Subdivision Comments

From: Jesse Cox, Environmental Health Supervisor

Date: Feb 28, 2019

RE: LPF-19-00001

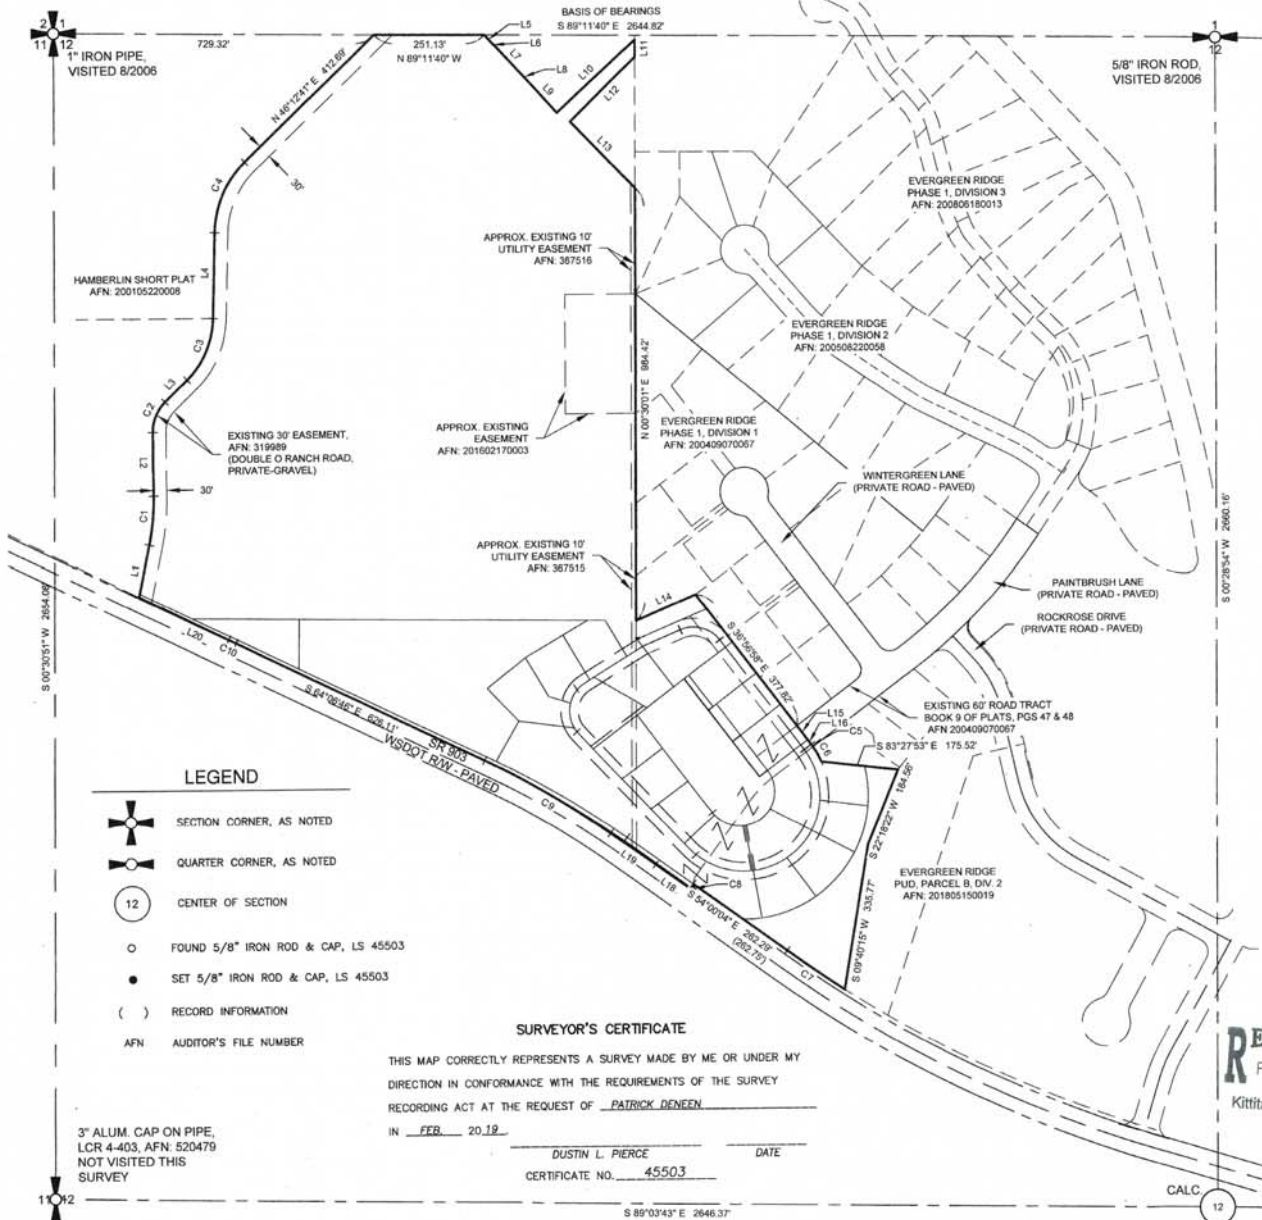
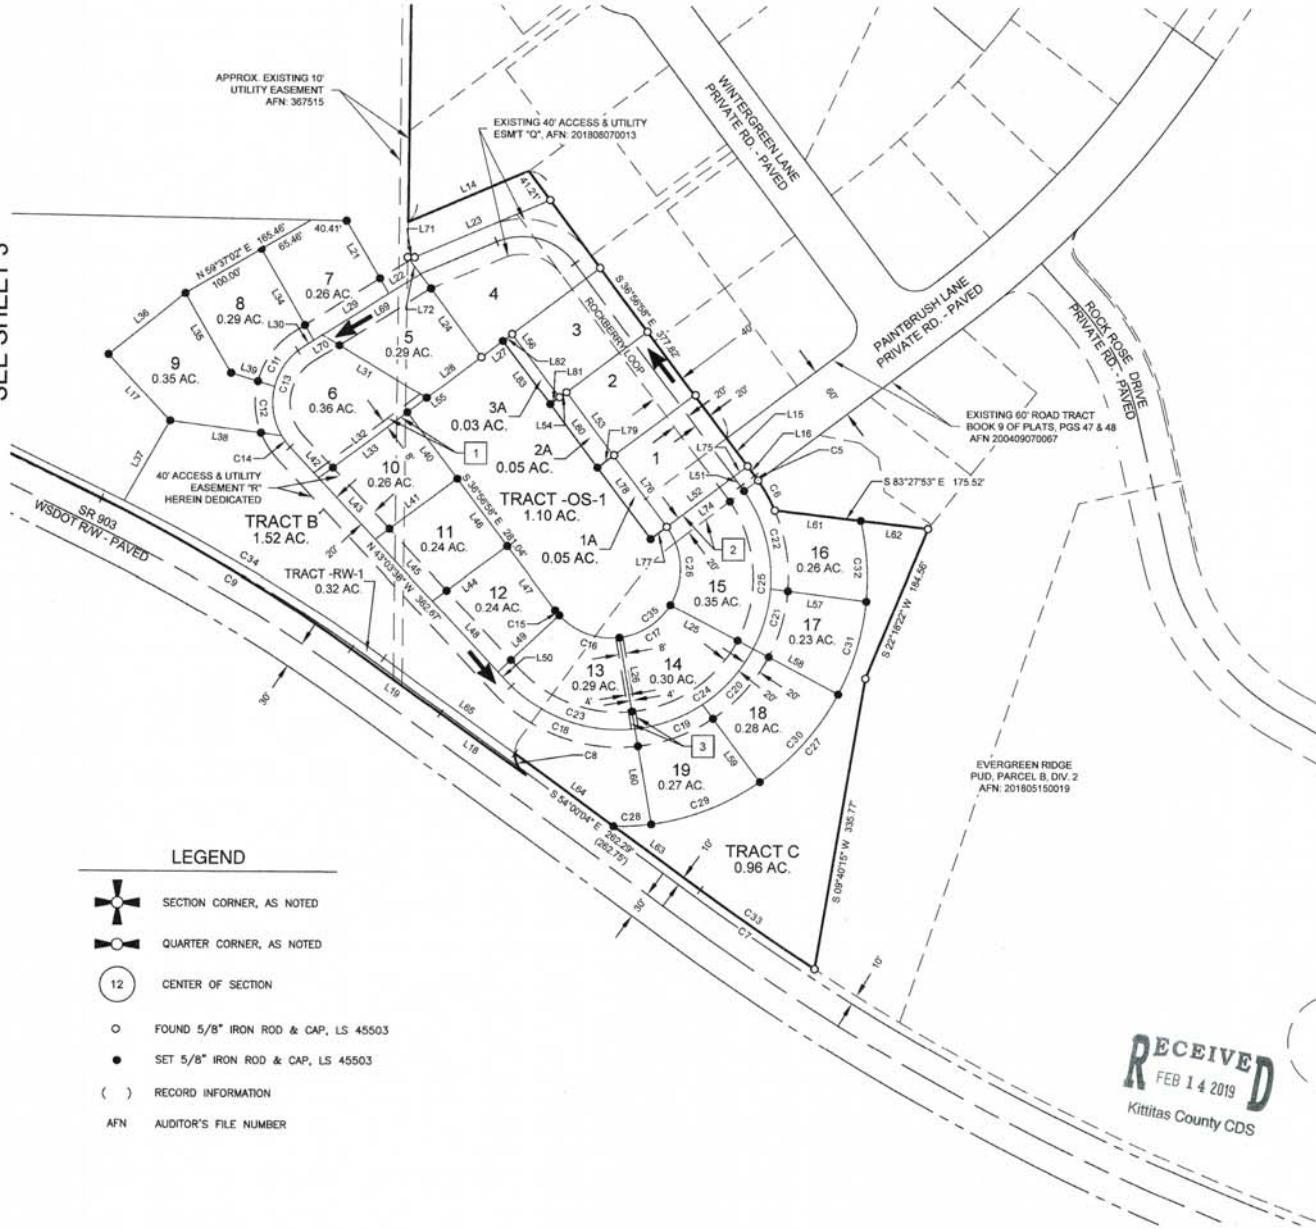
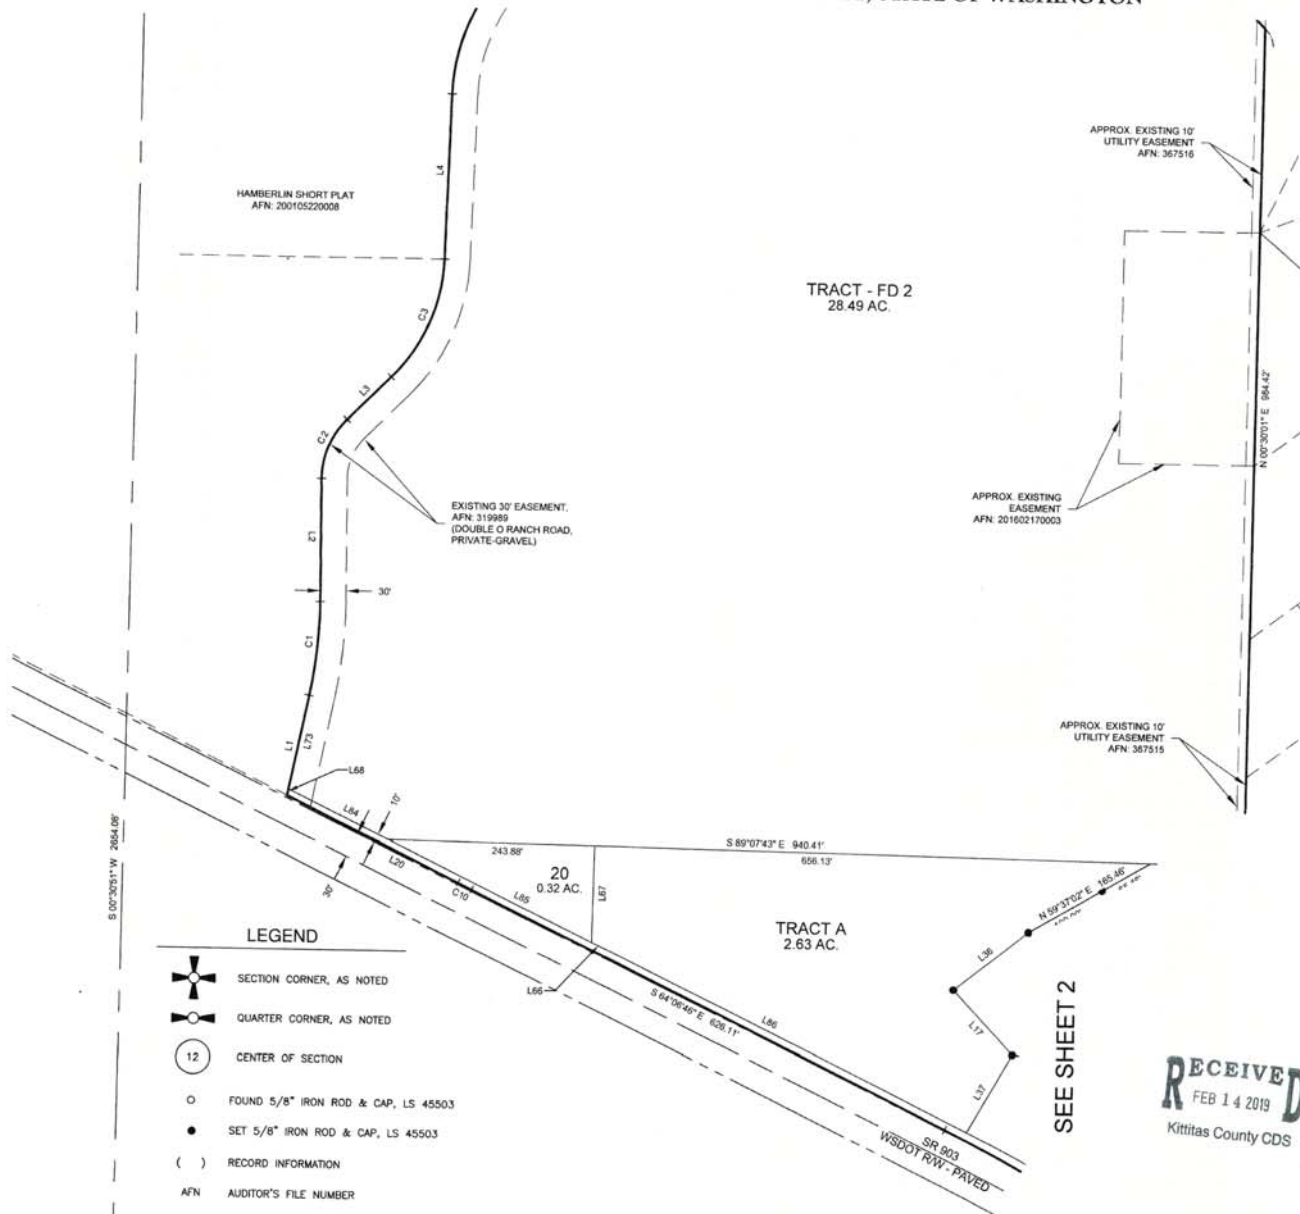
- B-1** The applicant shall obtain approval from DOH that the existing Group A public water system can adequately serve the Evergreen Ridge Planned Unit Development Rockberry Loop Plat project.

- C-1** “Metering is required for all new uses of domestic water for residential well connections and usage must be recorded in a manner consistent with Kittitas County Code Chapter 13.35.027 and Ecology regulations.”
- C-2** “The approval of this division of land provides no guarantee that use of water under the ground water exemption (RCW 90.44.050) for this plat or any portion thereof will not be subject to curtailment by the Department of Ecology or a court of law.”
